Rezoning Transportation Analysis

Petition Number: 2023-044

| Date | Description |
|----------|-------------------|
| 07-26-23 | First Review (TM) |

MORRIS HOLDINGS II, LLC
DEVELOPMENT STANDARDS
01/30/23
ZONING PETITION NO. 2023-

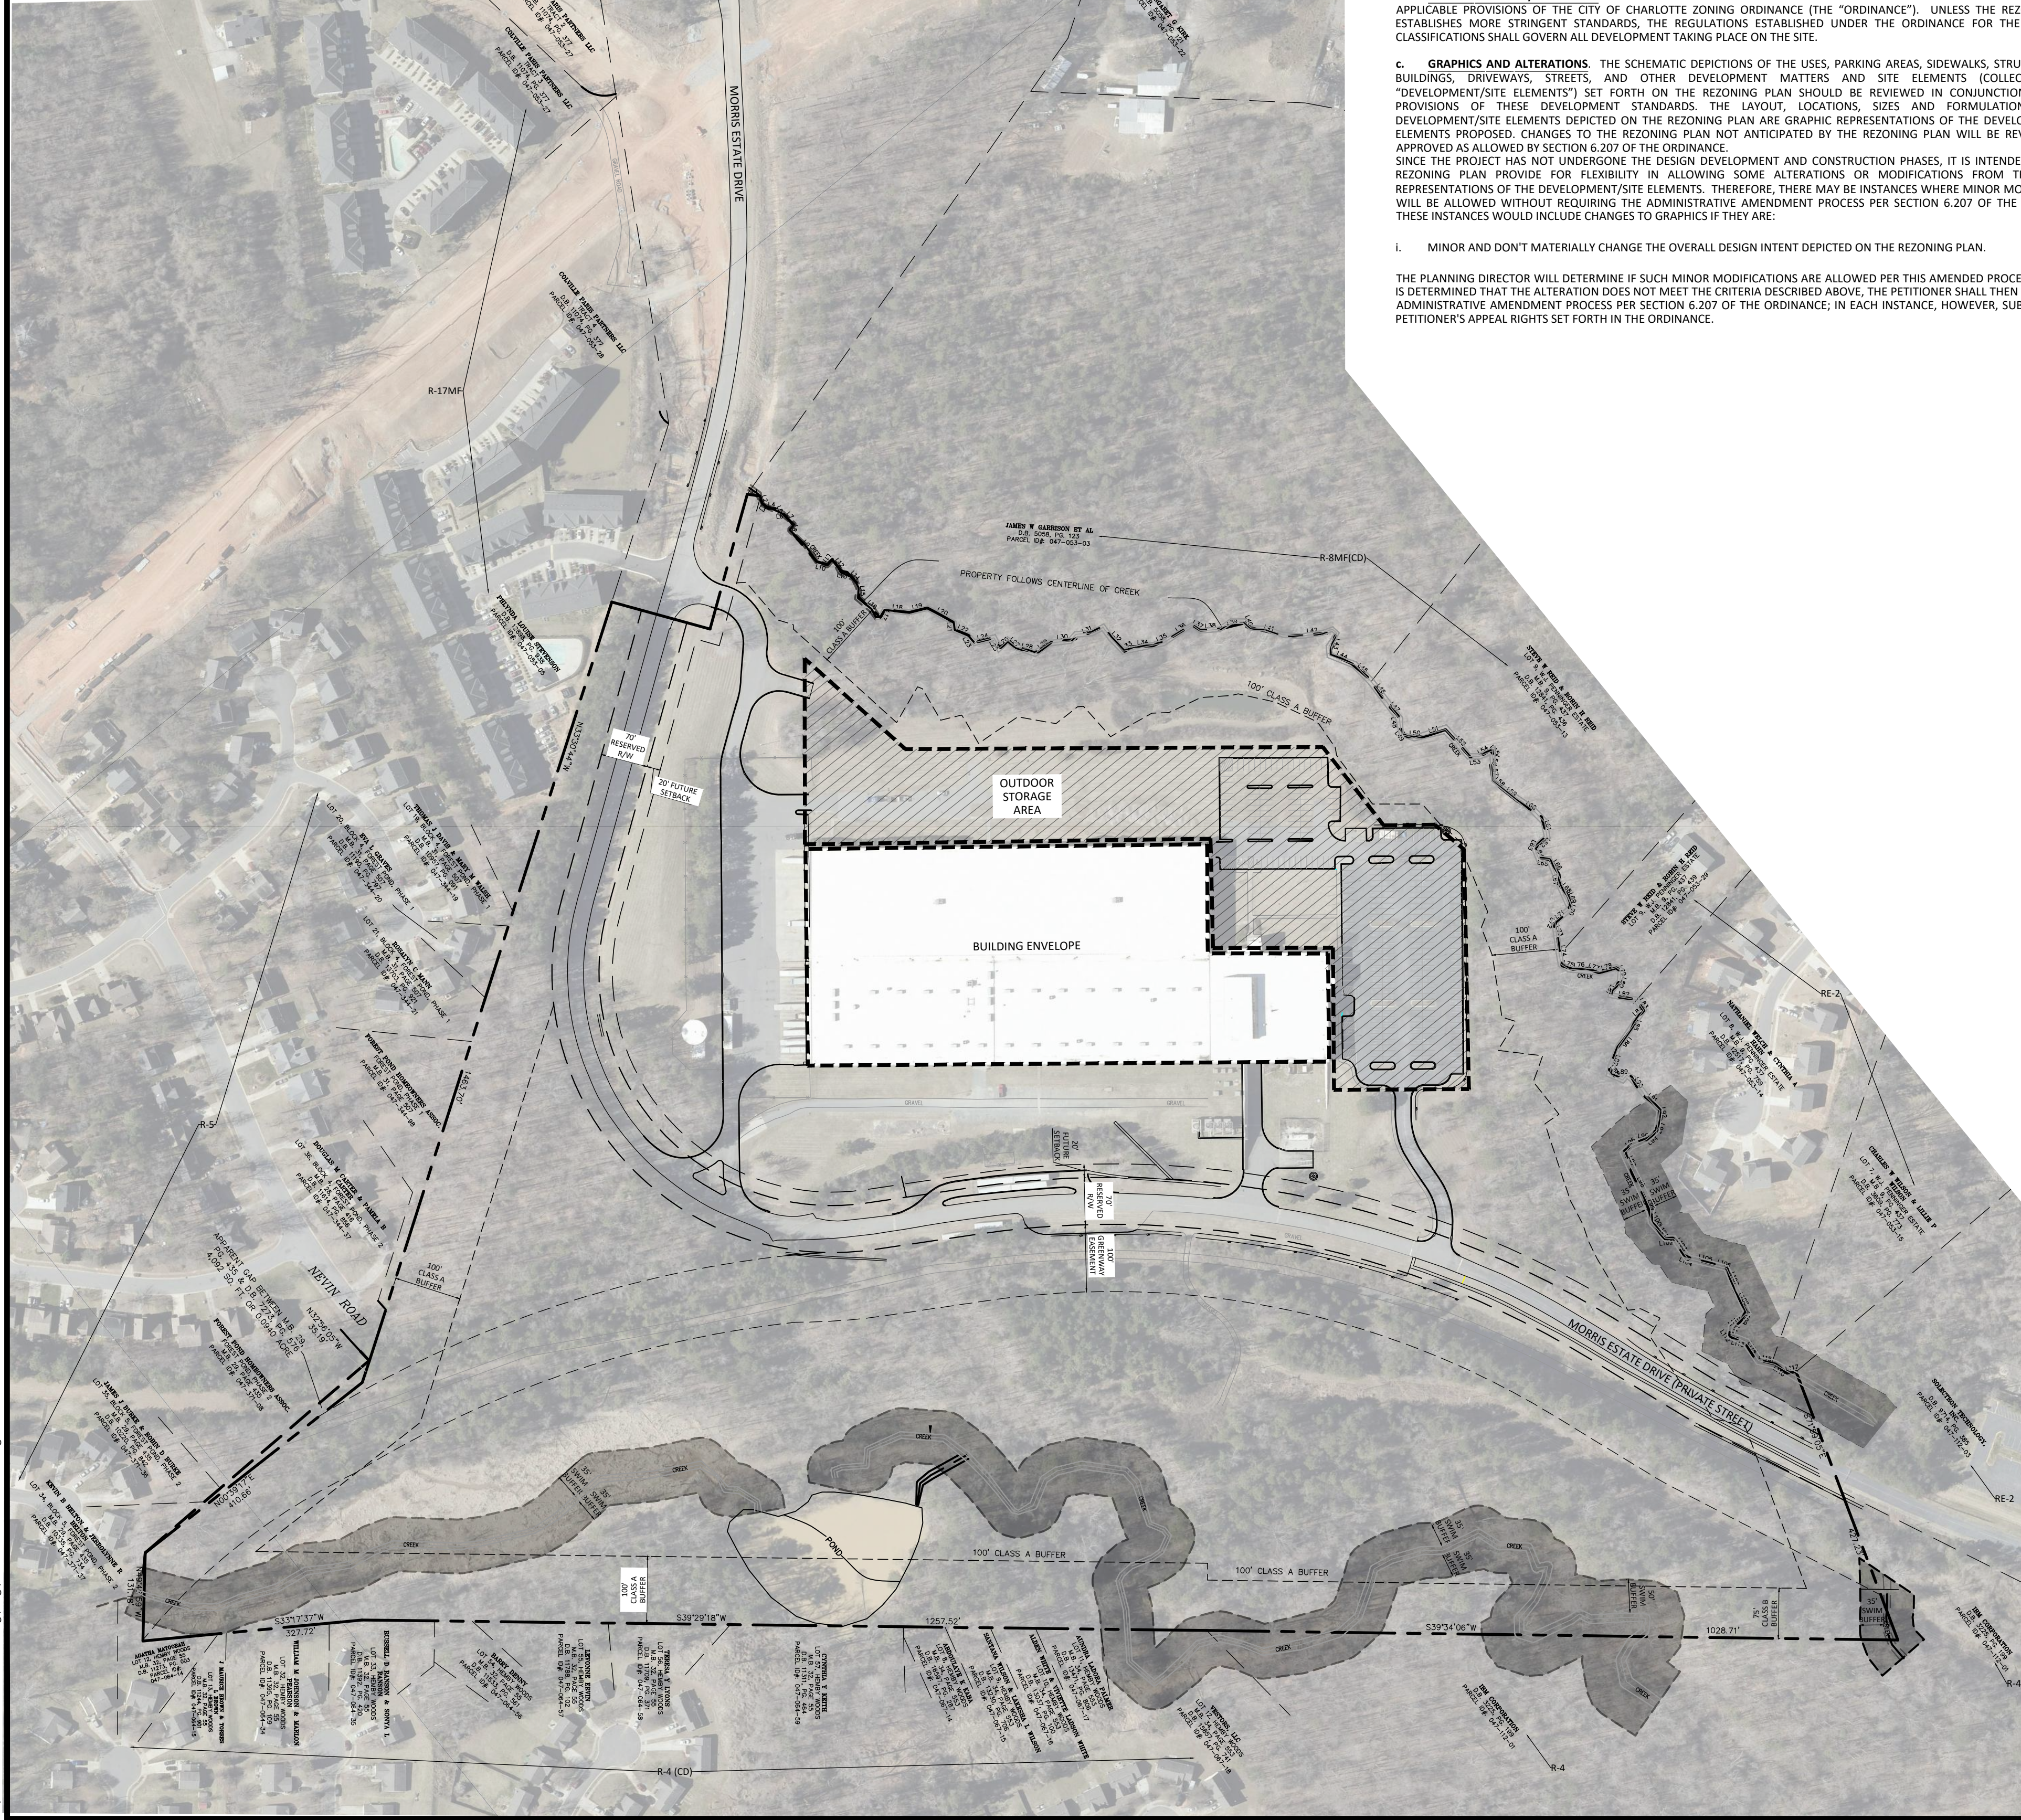
- a. **Morris Estates Road:** Location of curb and gutter to be moved to 24-feet from roadway centerline to accommodate the Charlotte Streets Map with a roadway typical section of 2+ Avenue with Bike Lanes.

NOTE: Additional distance from center line to back of curb may be required in locations where a median is present or around intersections and interchanges.

3. Revise site plan and conditional note(s) to commit to reserving 80-feet of right-of-way from the road centerline. The site plan shall label and dimension the right-of-way from the road centerline.

4. Add a conditional note specifying "A Right-of-Way Encroachment Agreement is required for the installation of any non-standard item(s) (irrigation systems, decorative concrete pavement, brick pavers, etc.) within a proposed/existing City-maintained street right-of-way by a private individual, group, business, or homeowner's/business association. An encroachment agreement must be approved by CDOT prior to construction/installation. Contact CDOT for additional information concerning cost, submittal, and liability insurance coverage requirements."

5. Add a conditional note specifying "All transportation improvements will be approved and constructed before the site's first building certificate of occupancy is issued. The petitioner may phase transportation improvements if said improvements and phasing are explicitly described in site plan notes."

6. Add conditional note specifying "All public roadway improvements will be subject to the standards and criteria of CDOT and NCDOT, as applicable, to the roadway improvements within their respective road system authority. It is understood that such improvements may be undertaken by the Petitioner on its own or in conjunction with other development or roadway projects taking place within the broad north eastern Mecklenburg area, by way of a private/public partnership effort or other public sector project support."
